Meadowlake Industrial Park Filing No. 1 Preliminary Plan Traffic Impact Study

NOVEMBER 15, 2024

EPC PCD File No.: SP236
LSC #S234040

LSC Responses to TIS Redline Comments

Deviation Exhibit

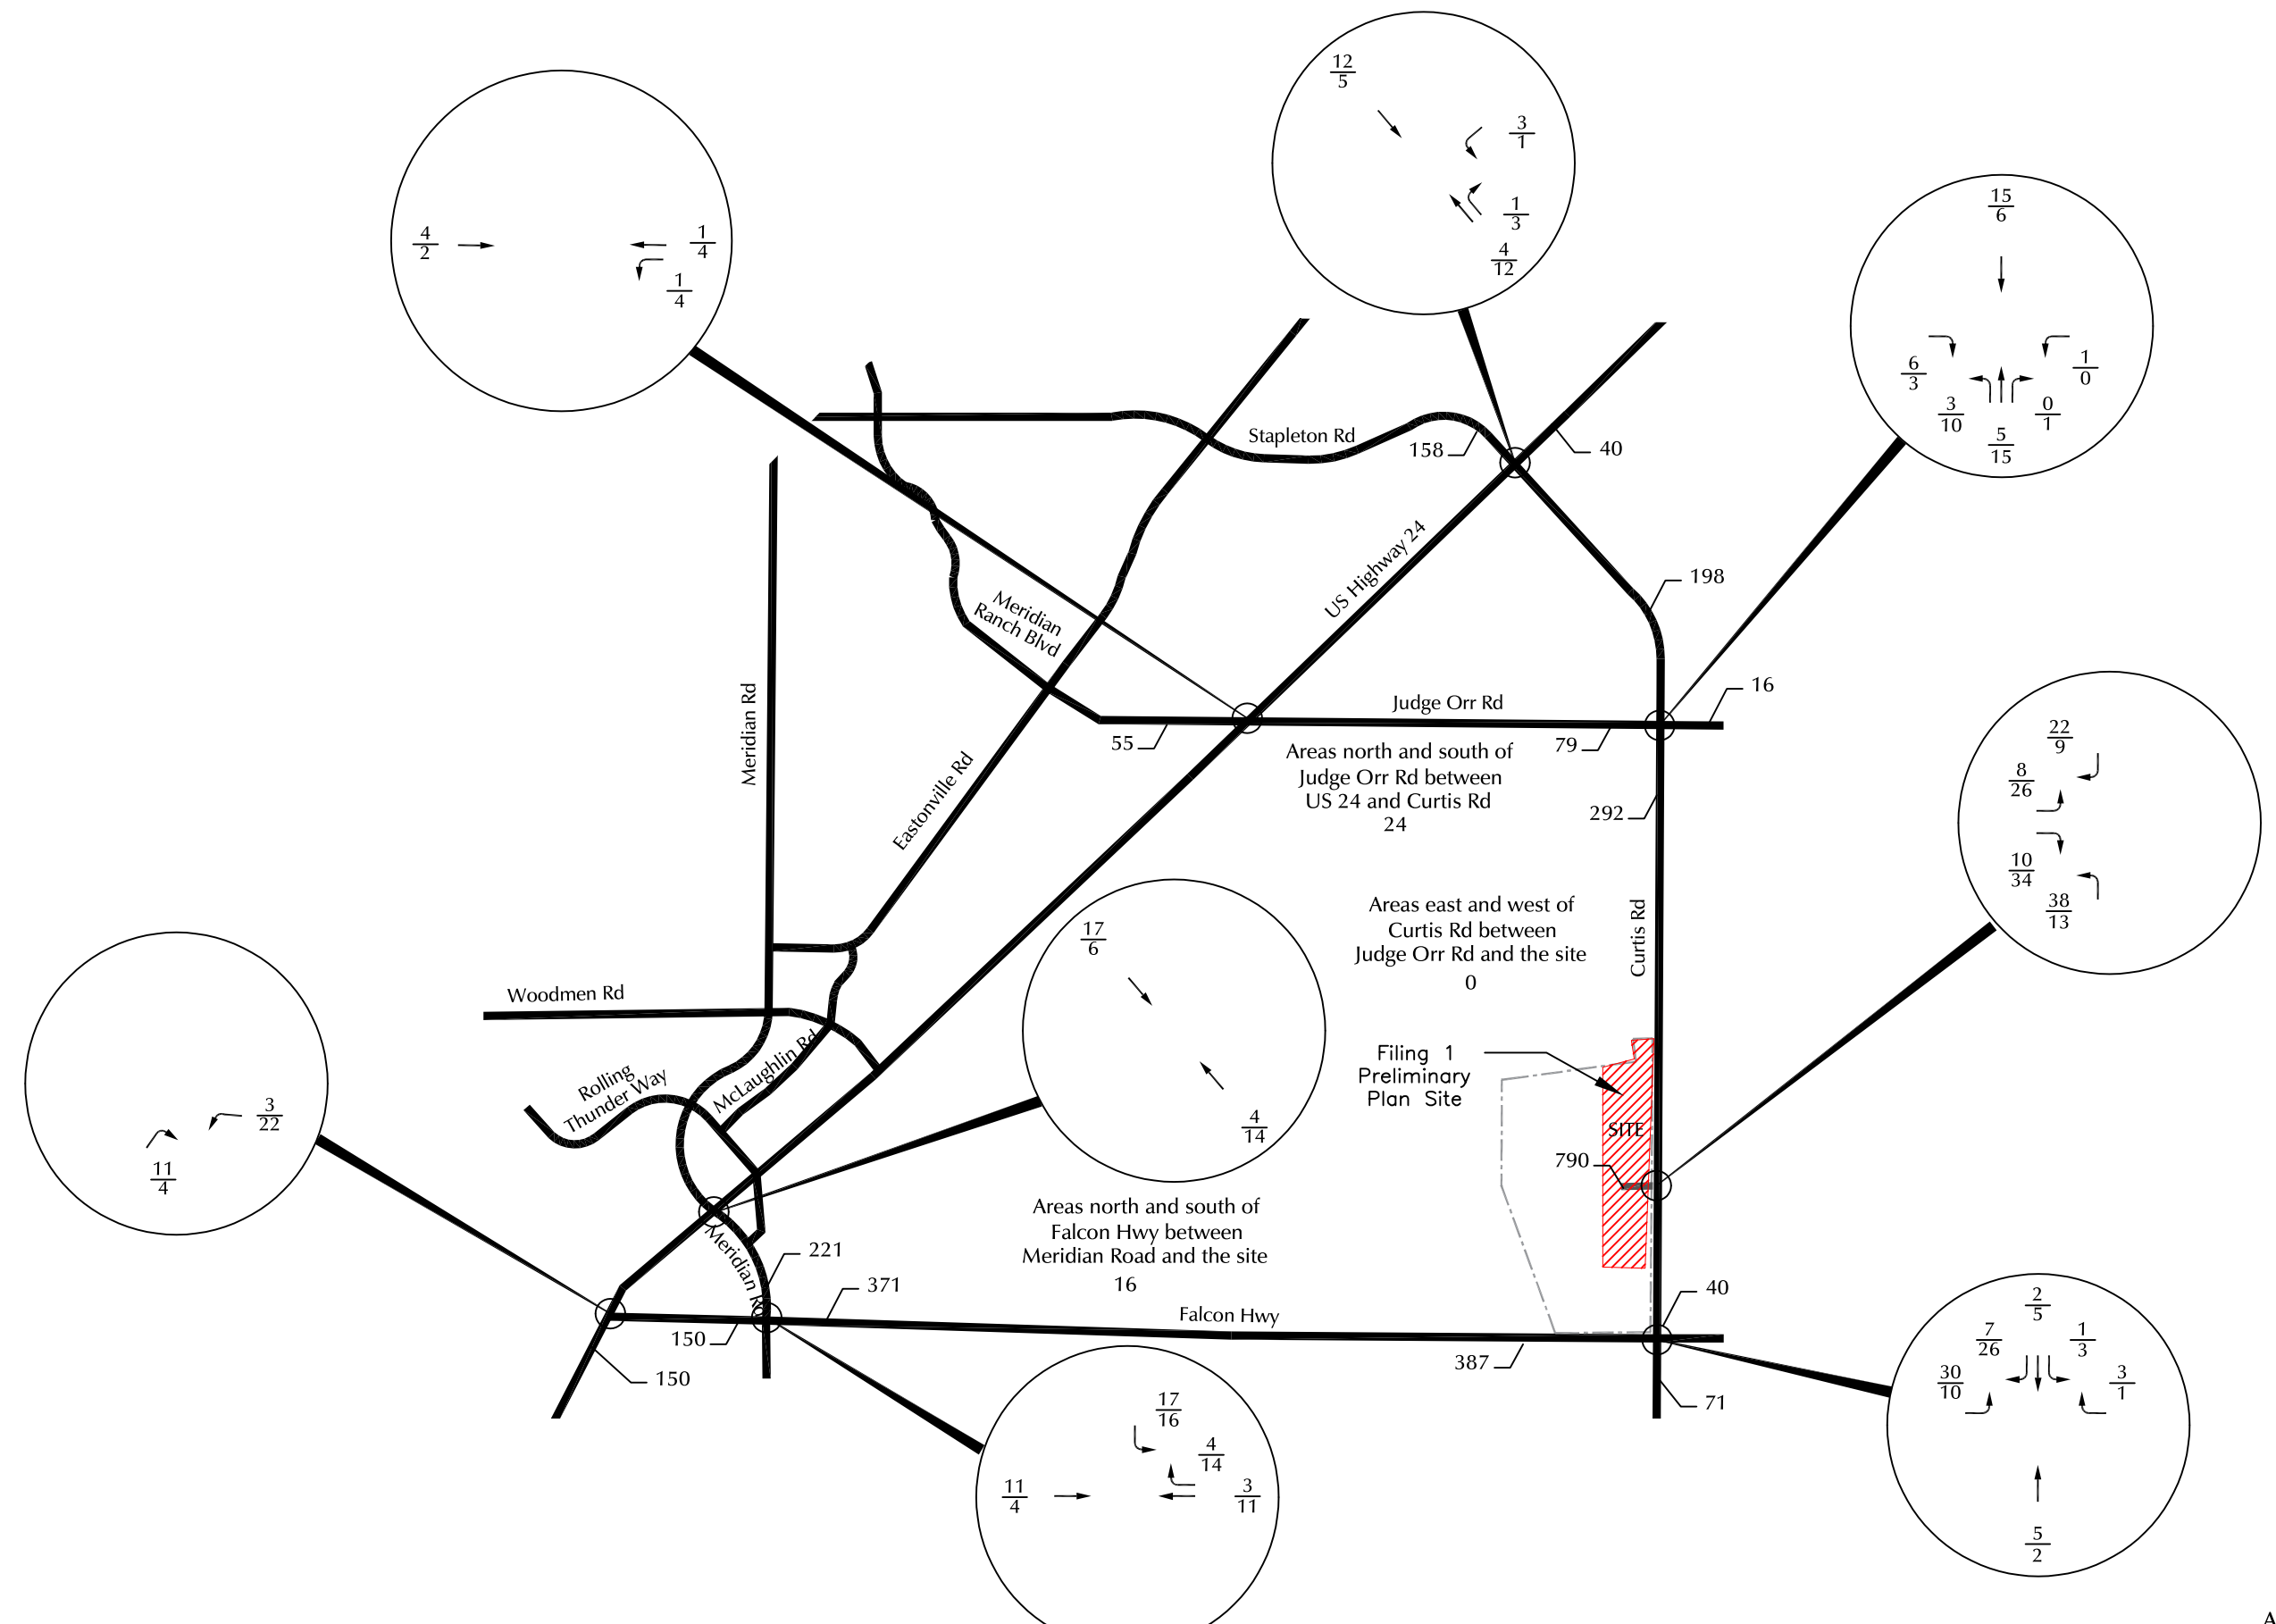
see comments on deviation submitted

[see comments on deviation submitted](#)

Comment noted. See LSC responses to deviation comments.
